Engineers Comments Regarding Surface Water Drainage

Application Reference:	BN/76/26/DOC	Reviewer Reference:	ADC/EXT2/113
Planning Officer:	Amber Willard	Date of Review:	07/09/2026
Site Name:	Land South Of Wandleys Lane Eastergate PO20 3SE		
Application Description:	Approval of details reserved by condition under BN/46/25/PL relating to conditions 4- Surface Water Drainage and 9- Maintenance & Management of Sustainable Drainage Scheme.		
Assessment Number:	2

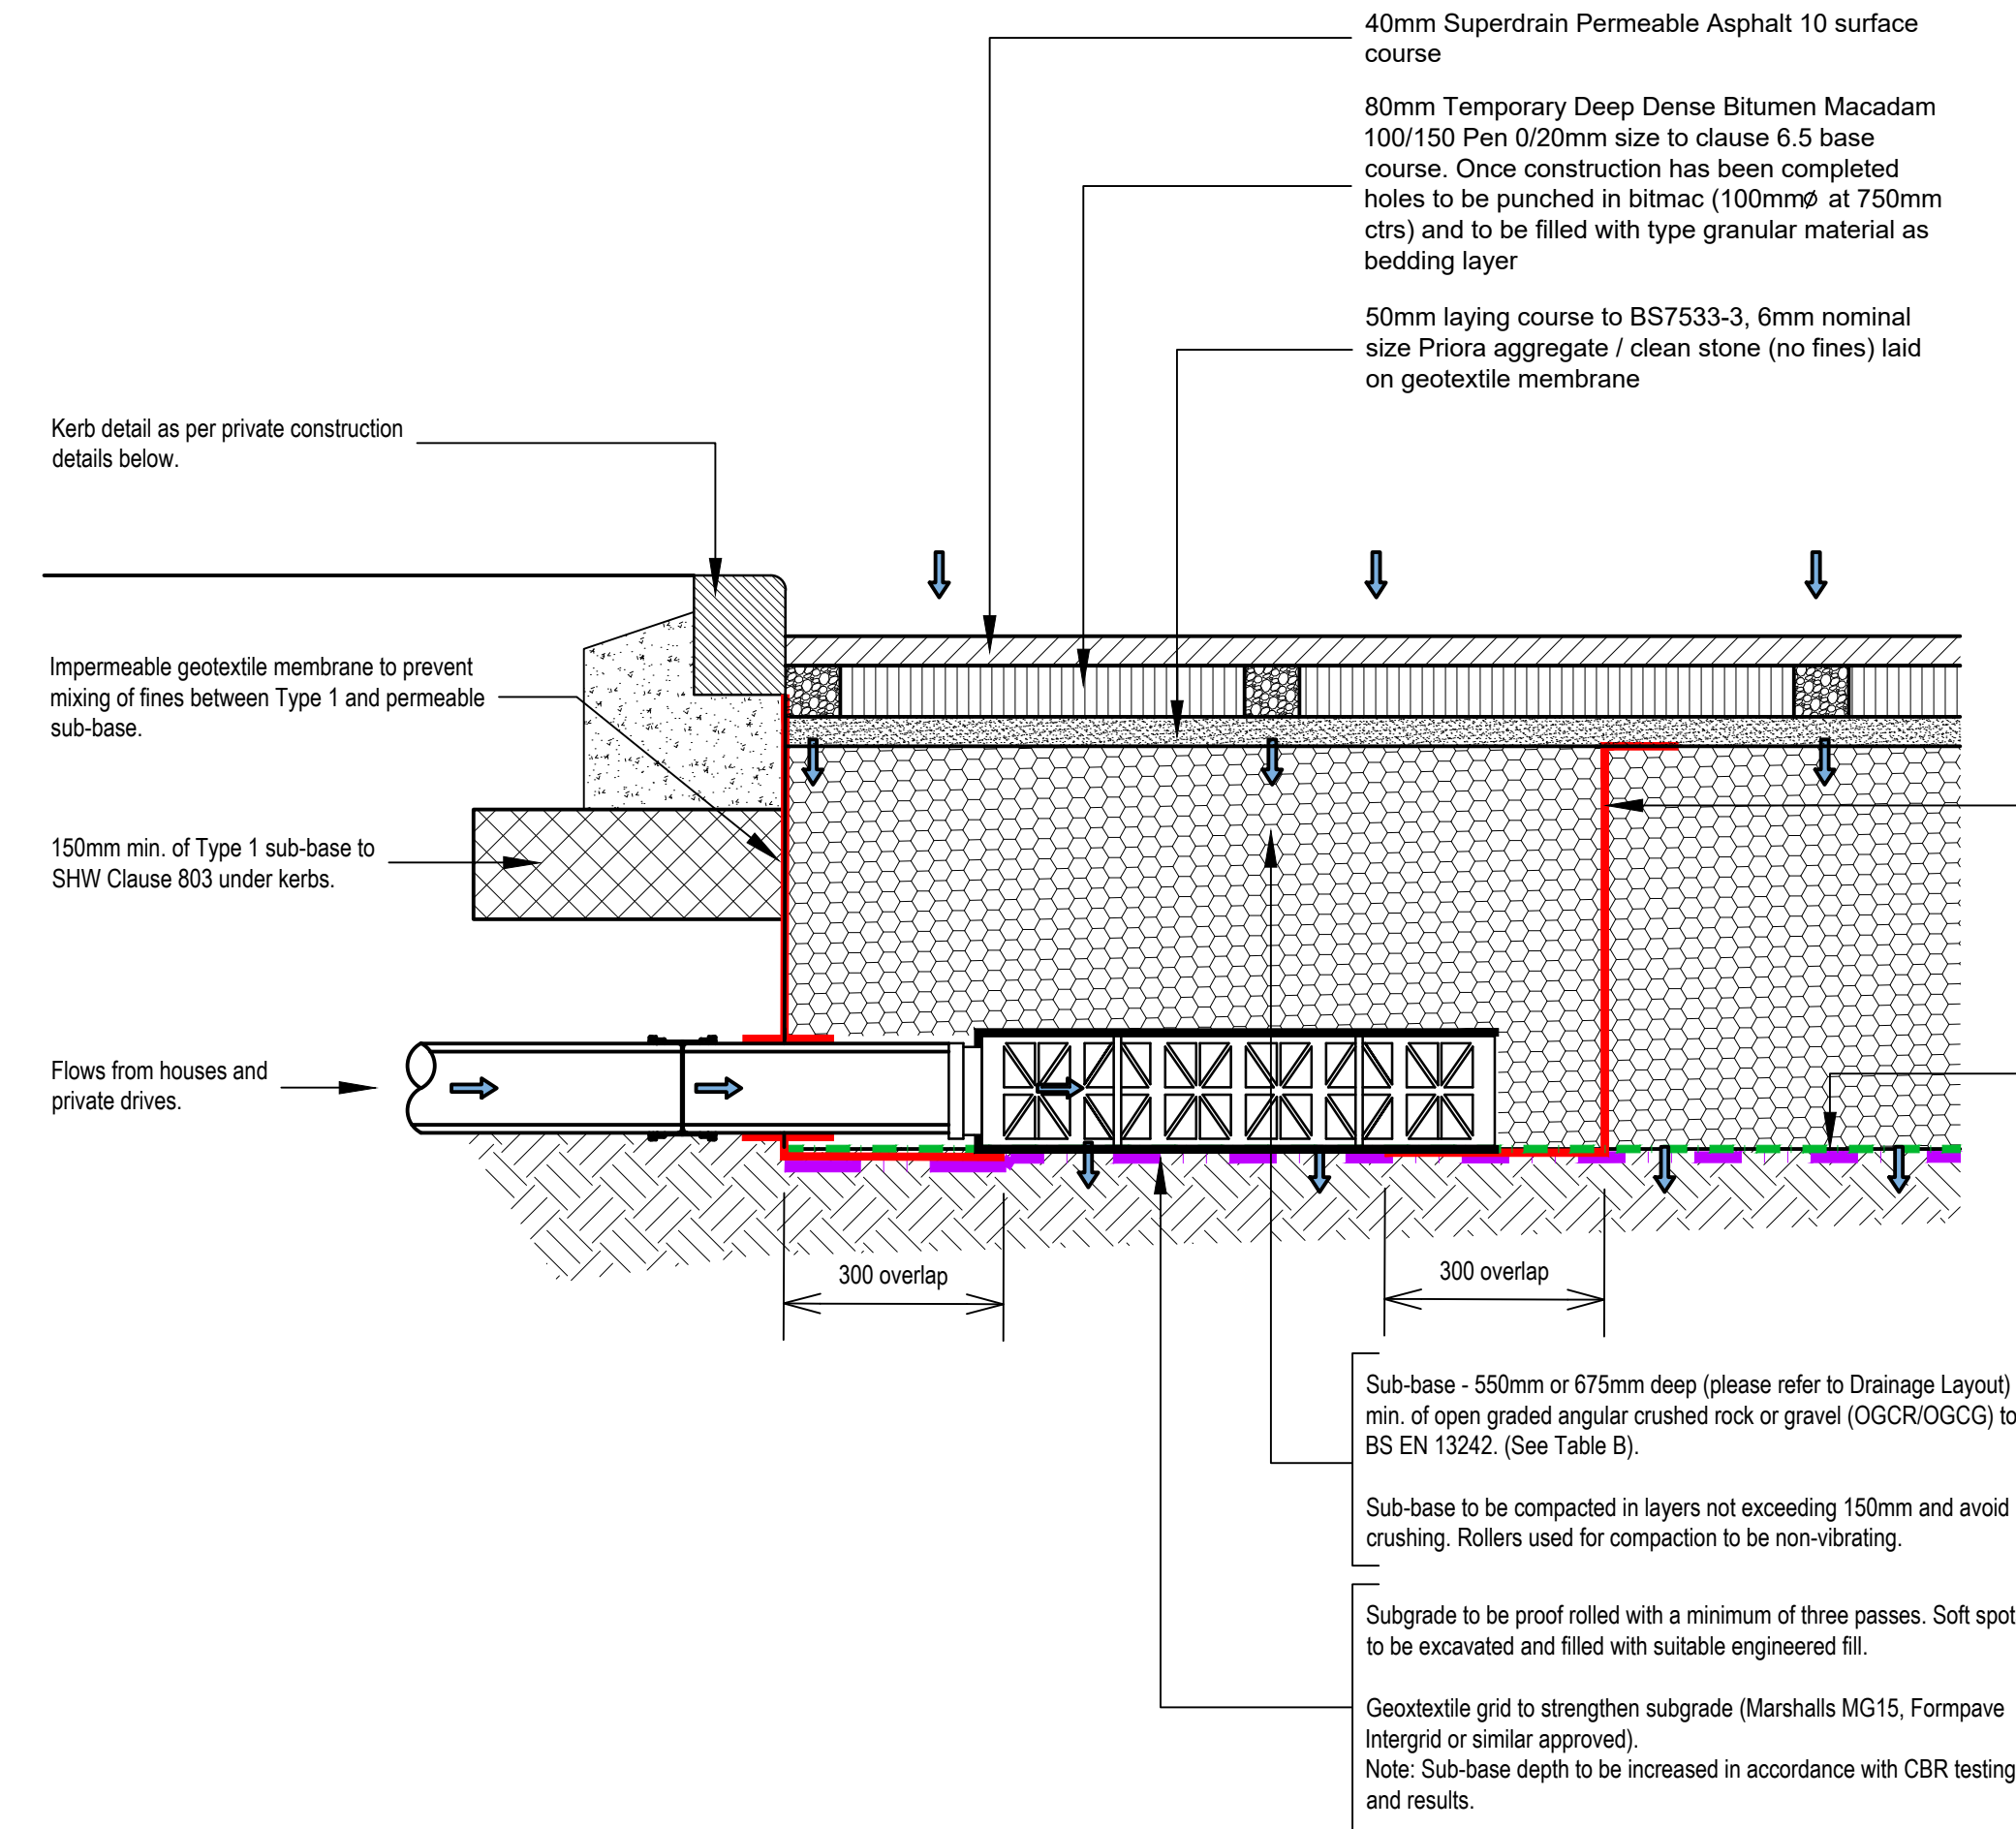
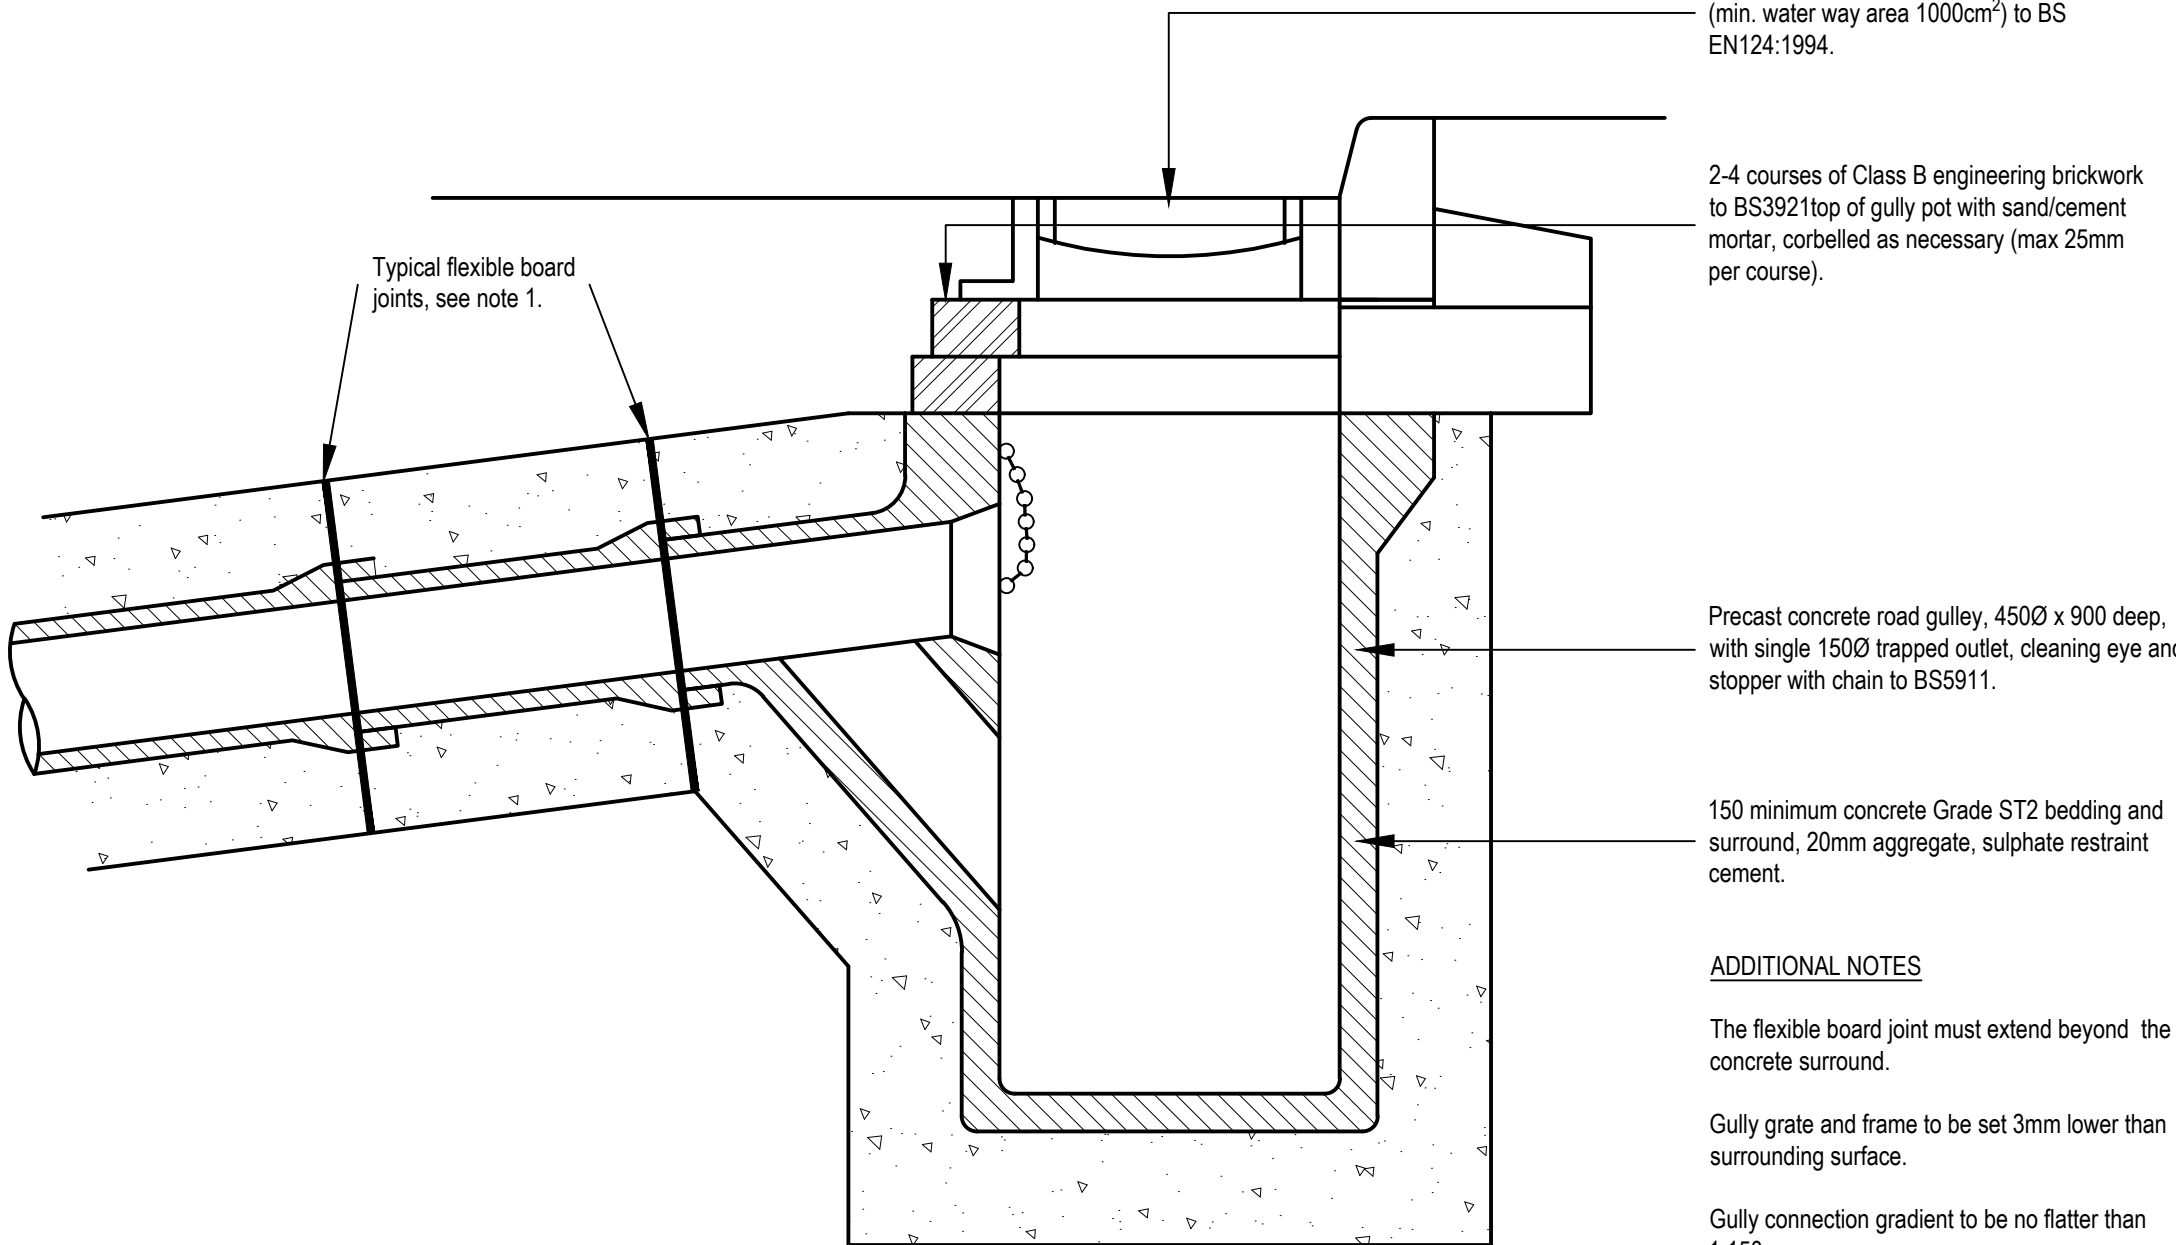
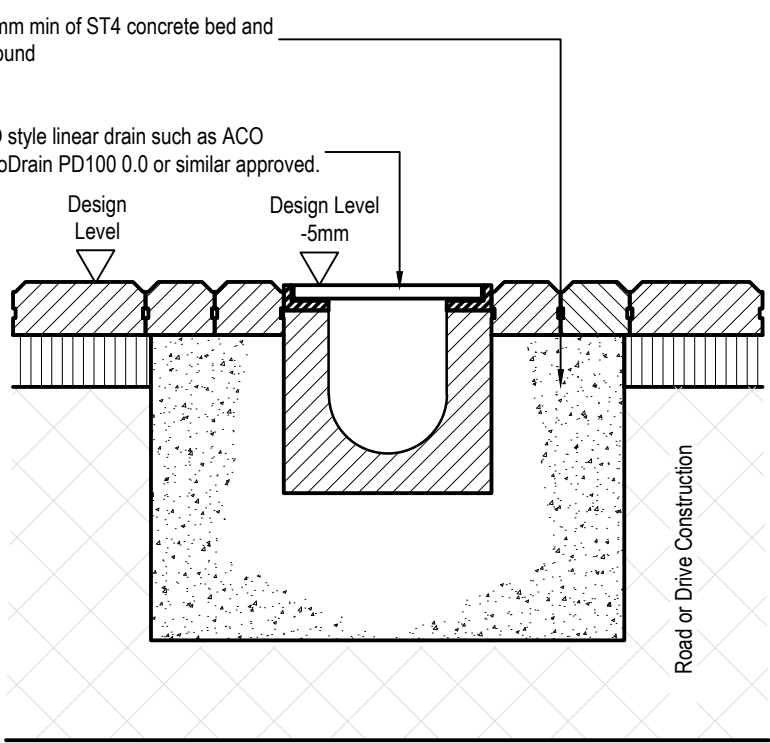
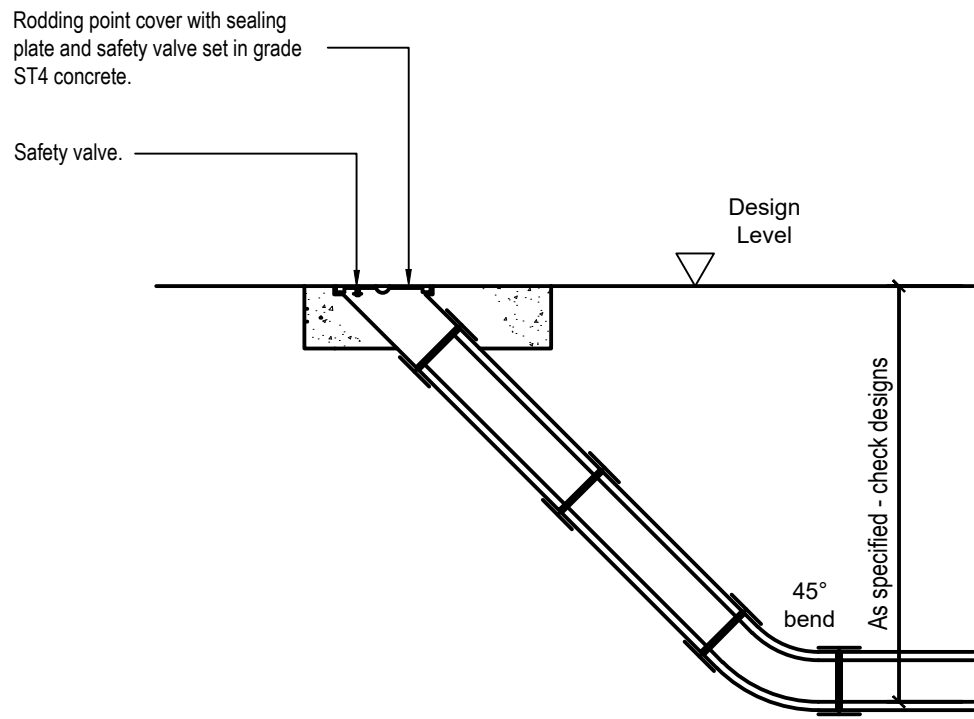
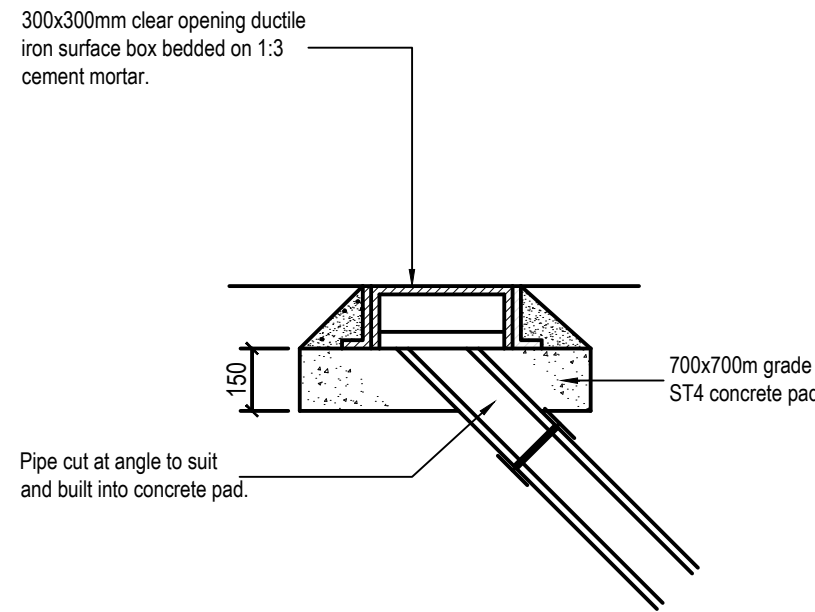
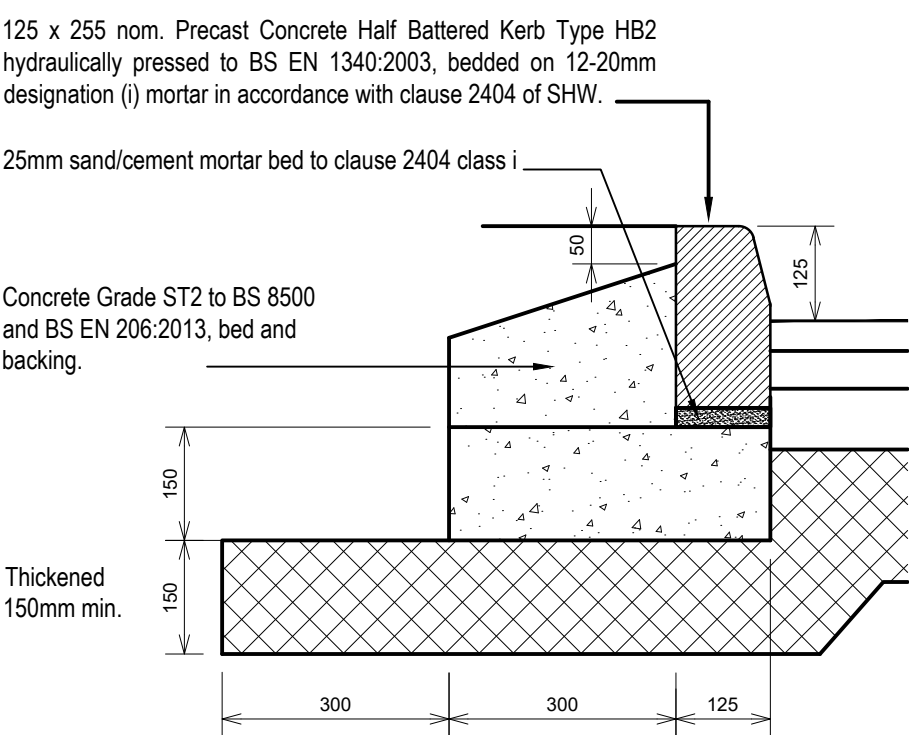
14.	Construction detail updated. Please refer to drg no. 476988-911_P03 - Construction Details-- Sheet 1.	Noted. Comment closed.			
15.	Detail updated with correct reference. Please refer to drg no. 476988-911_P03 - Construction Details-- Sheet 1.	Noted. Comment closed.

An ACO drainage channel has been added along the highway/private boundary interface. Please refer to drg. No. 476988-501_P04- Drainage Layout.				
18.	Construction detail updated. Please refer to drg no. 476988-911_P03 - Construction Details— Sheet 1.	Noted. Comment closed.

19.	Note added to construction details. Please refer to drg no. 476988-911_P03 - Construction Details-- Sheet 1.	Noted. Comment closed.			
20.	Note reviewed and amended as necessary. Please refer to drg no. 476988-912_P03 - Construction Details— Sheet 1.	Noted. Comment closed.
